A1 Birtley to Coal House

Scheme Number: TR010031

Statement of Common Ground with Sunderland City Council

APFP Number:	
Planning Inspectorate Scheme Reference	TR010031
Application Document Reference	TR010031/7.5B
Author:	A1 Birtley to Coal House Project Team, Highways England

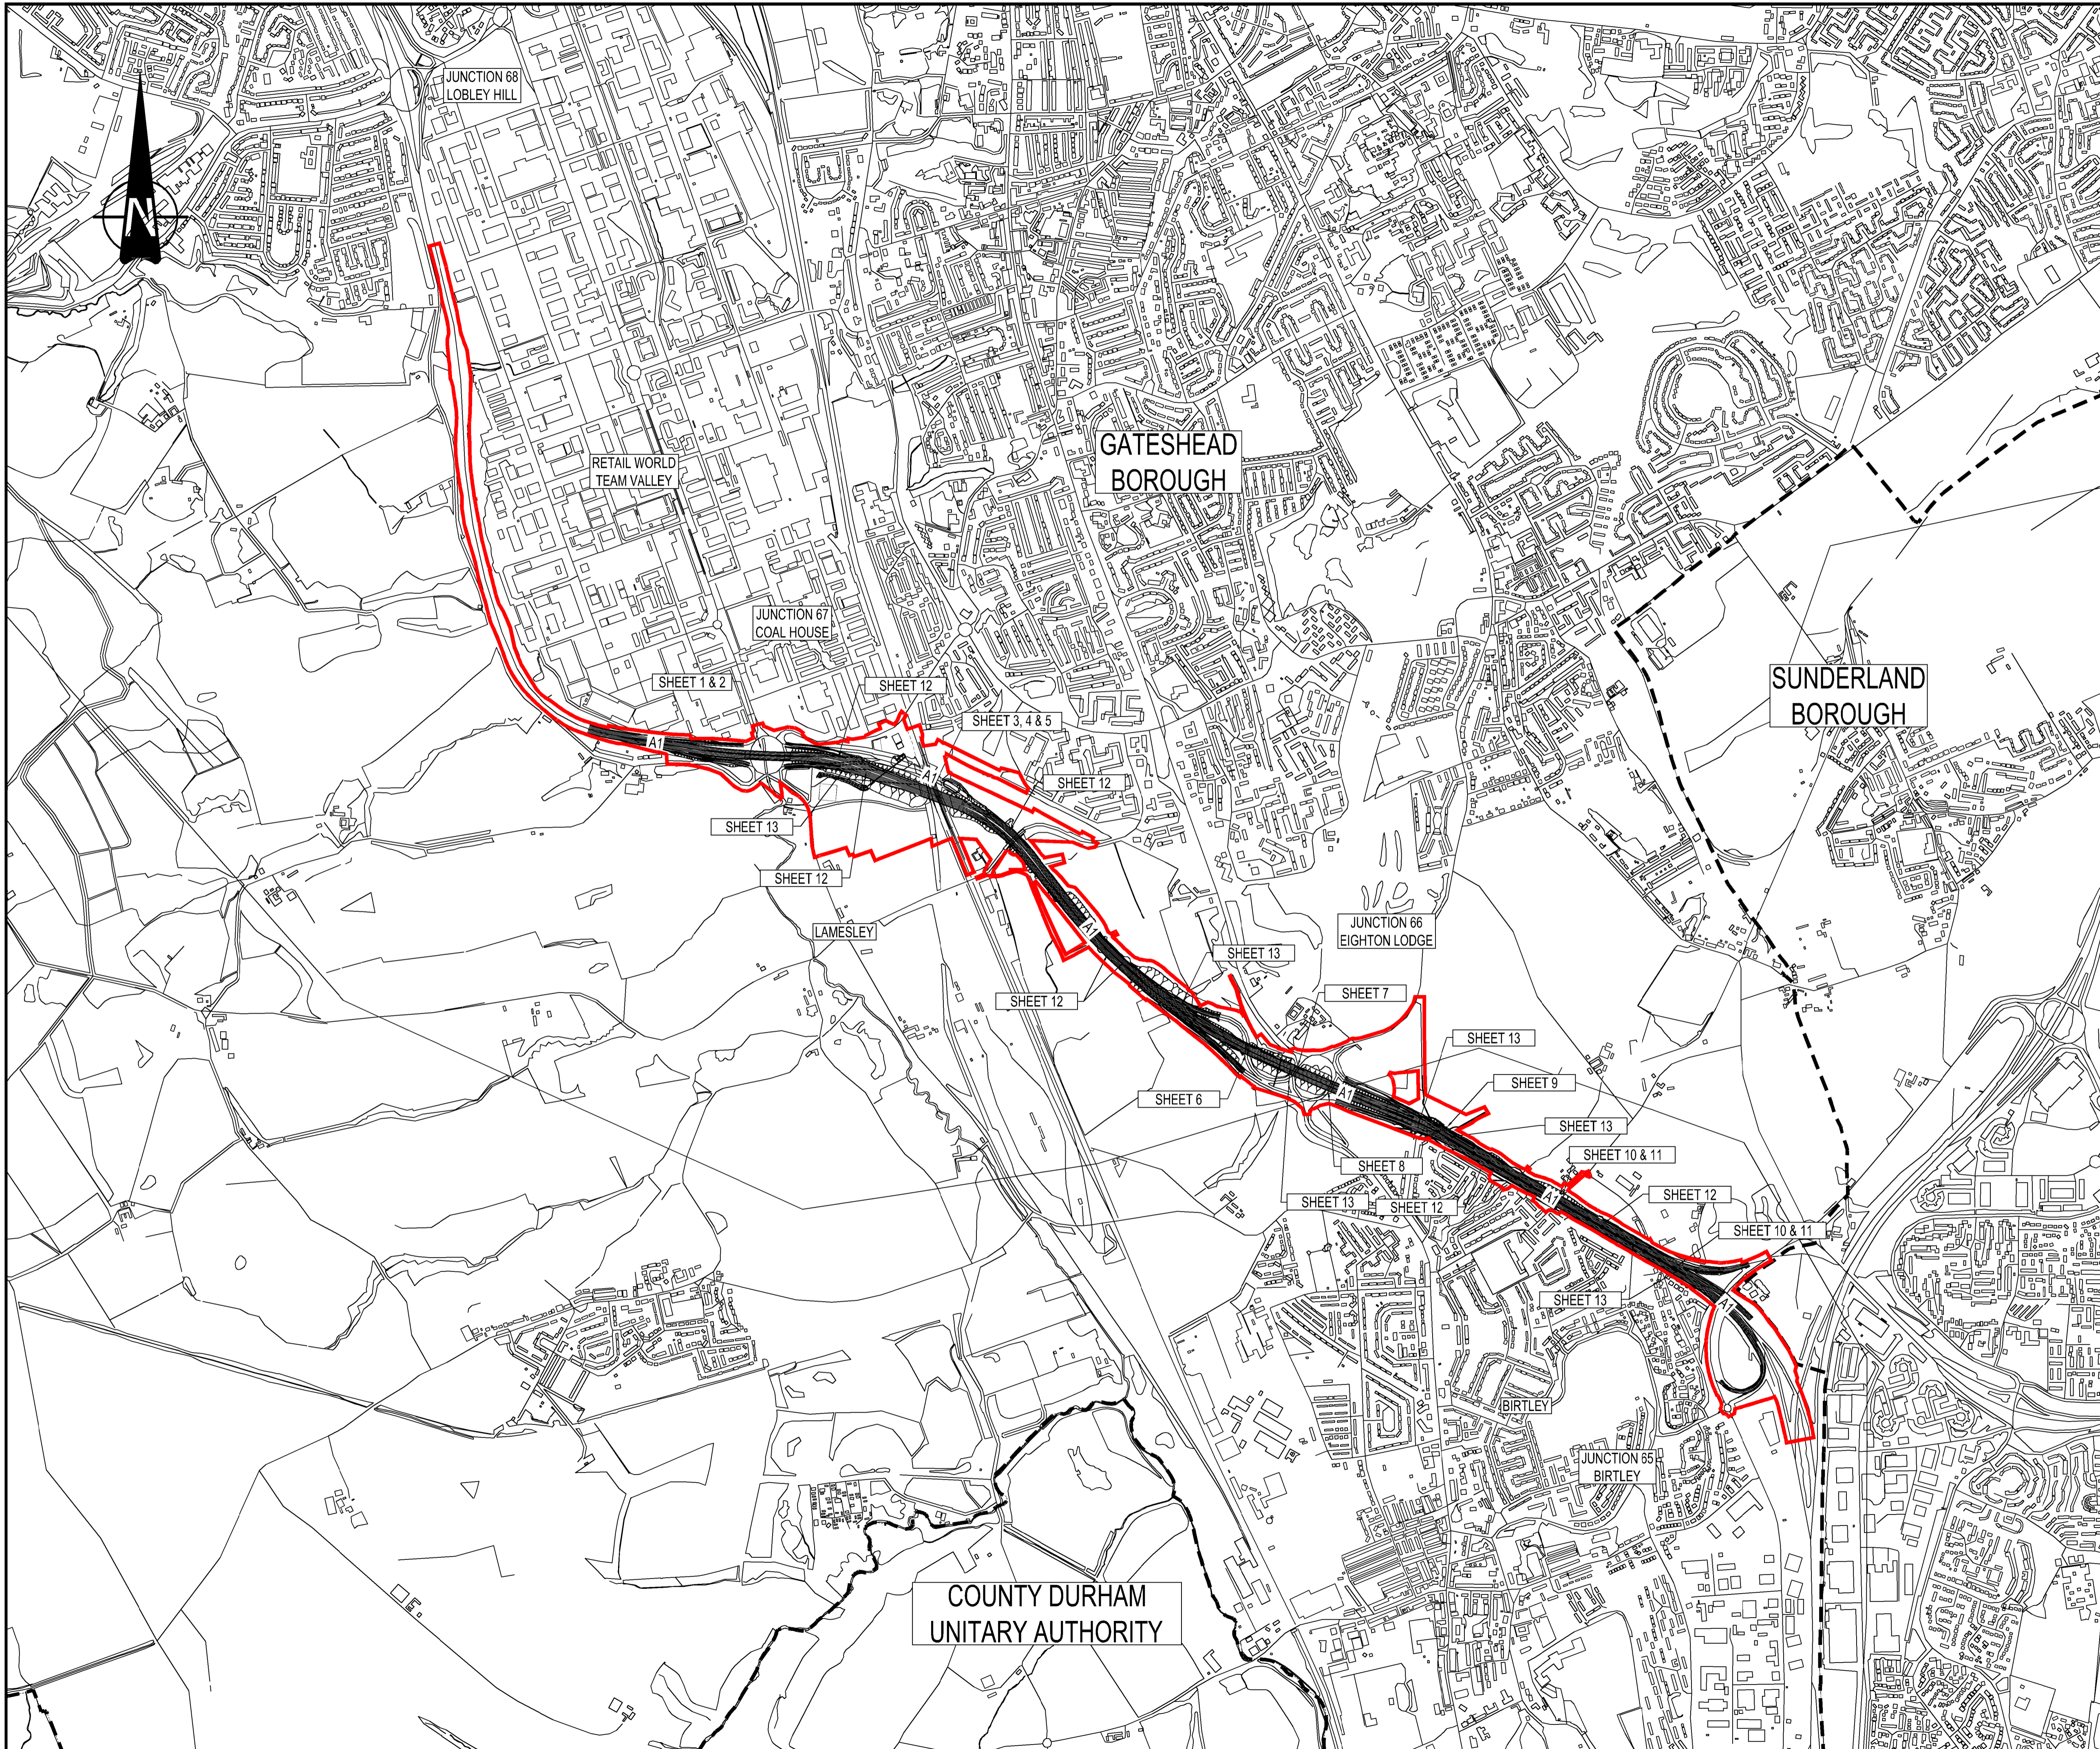
Section	Sub-section	Sunderland City Council Response	Highways England Position	Status
Structures Engineering Drawings and Sections [APP-011]	All	There are some text errors within the submission drawings relating to the naming of local authority areas of Gateshead, Sunderland and Durham which should be corrected. These include reference to 'Sunderland Borough', which should be corrected to 'Sunderland City Council.'	<p>The Proposed Scheme has been detailed in depth in numerous drawings and Sections provided as part of the submission, including the proposed design of:</p> <ul style="list-style-type: none"> · The Viaduct and Embankment Options · Ramp at North Dene Footbridge · Lighting of the underpass · Public Rights of Way diversions. <p>Plans have been updated to correct errors identified.</p>	Agreed
